Application number: 2021/93565	
What is the application for?:	Removal of condition 5 (Construction Method Statement) on previous permission 20
Address of the site or building:	Land Adjacent, Hazeldene House, Stoney Bank Lane, Thongsbridge, Holmfirth, HD9 7LZ
Postcode:

Type of comment: An objection	
Do you wish your comments to be published on the website anonymously?	Yes
<p>I would like to object to the planning proposal 2021/93565.</p> <p>I would like to point out that the building of the proposed access road has already commenced. This is unfair to us who live on the side of the access road, as you the council have already in essence approved the construction without giving us fair warning or chance to formally submit our objections.</p> <p>Shame on you.</p> <p>Here is our official objection but it is clearly too late to impact the decision due to the fact that the work is already underway.</p> <p>The stated hours of work, especially at the weekend seems to be excessive. As homeowners who back onto the proposed road creation, we have already had to put up with an incredible amount of noise over the past three years. Initially with the new Stoney Bank Chase development, then subs

Client		ACUMEN	
Project		HAZELDENE HOUSE, STONEY BANK LANE, THONGSBRIDGE	
Project No	Drawing No	Rev	
2628	L(100) -	/	
Description			
ACCESS AND CONSTRUCTION ROAD RESTORATION PLAN

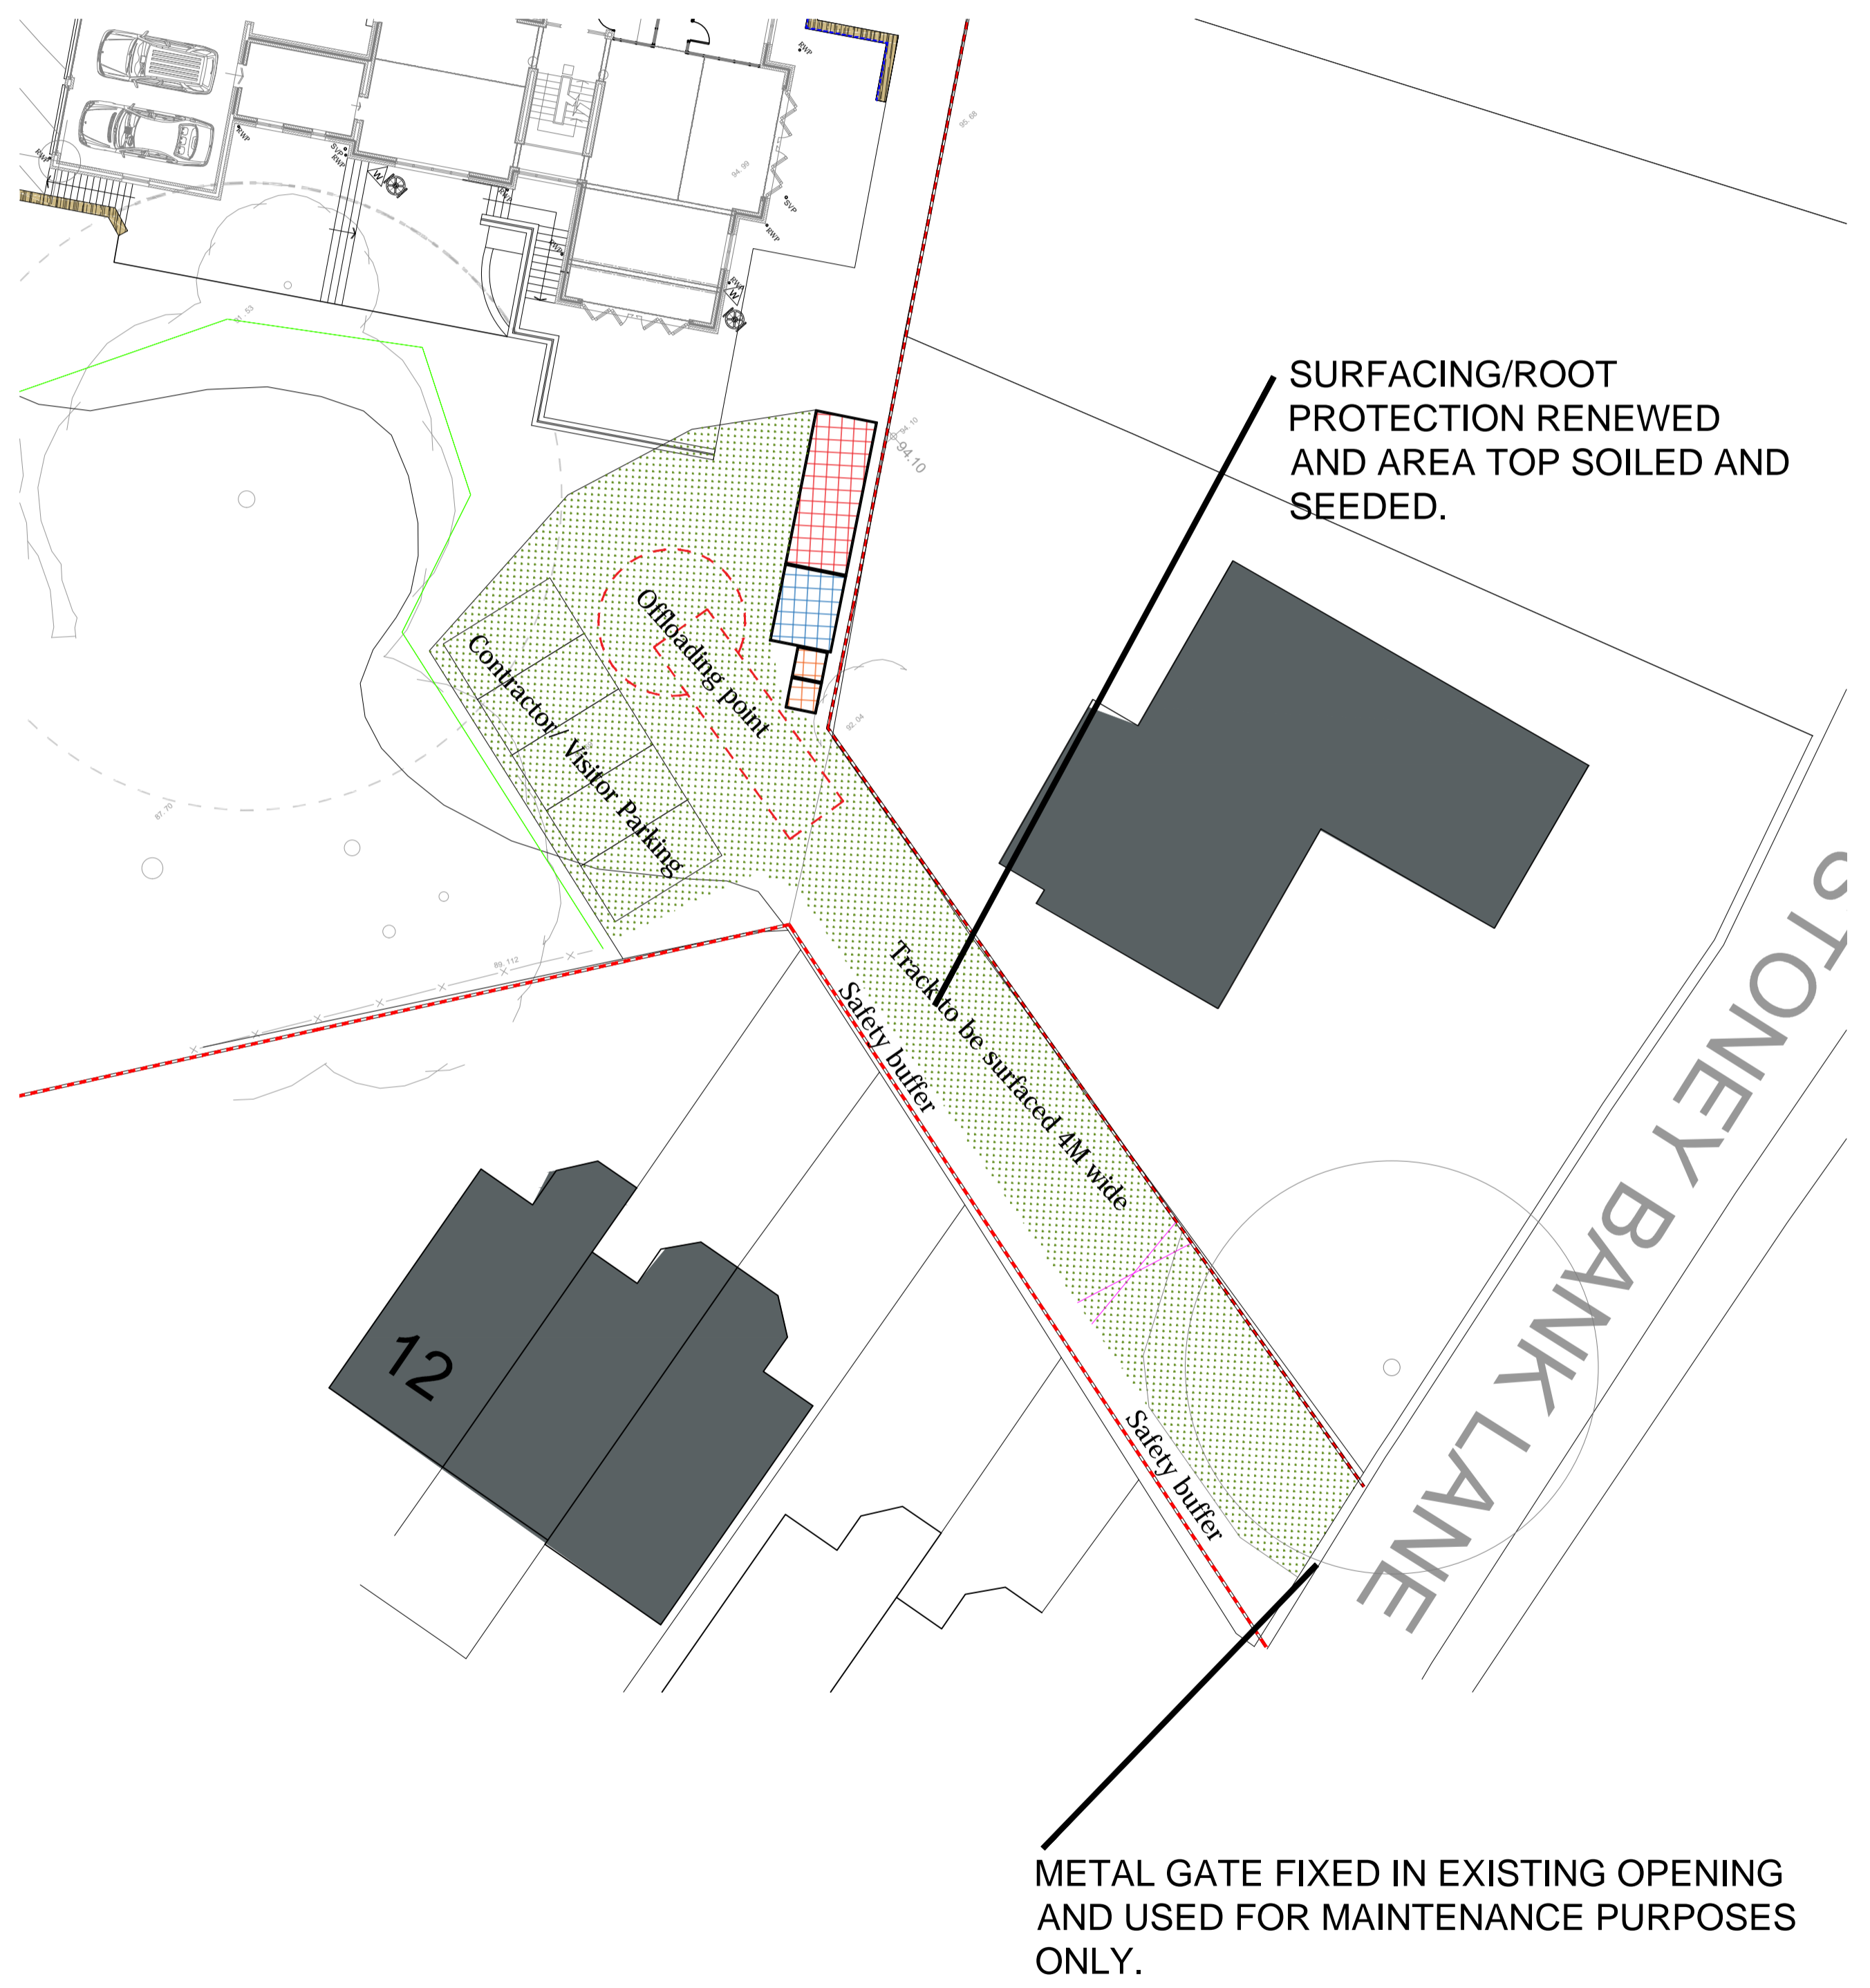
As we are homeowners which back onto the proposed road creation, we are extremely worried about the structural integrity of the wall which the road is being built on. There has been no structural assessment of the wall or any verification from a structural or civil Engineer as to whether the wall will be able to withstand a significant amount of heavy plant machinery.

The proposed road is also incredibly narrow. We are fearful of both the collapse of the wall due to the traffic which will be traveling on it plus the added fear of a wagon falling off the road and landing in our garden or worst still, crashing into our property.

The plans for the proposed access road make no reference to any drainage system. This again is something of a major concern to us homeowners. The building of the property 'Millside' has taken away a natural soakaway which has now resulted in our garden flooding whenever there is heavy rain. The proposed access road will only add to this flooding issue as there will be no drainage to remove the water. This means that the rainwater will run off the road into our garden adding to our misery.
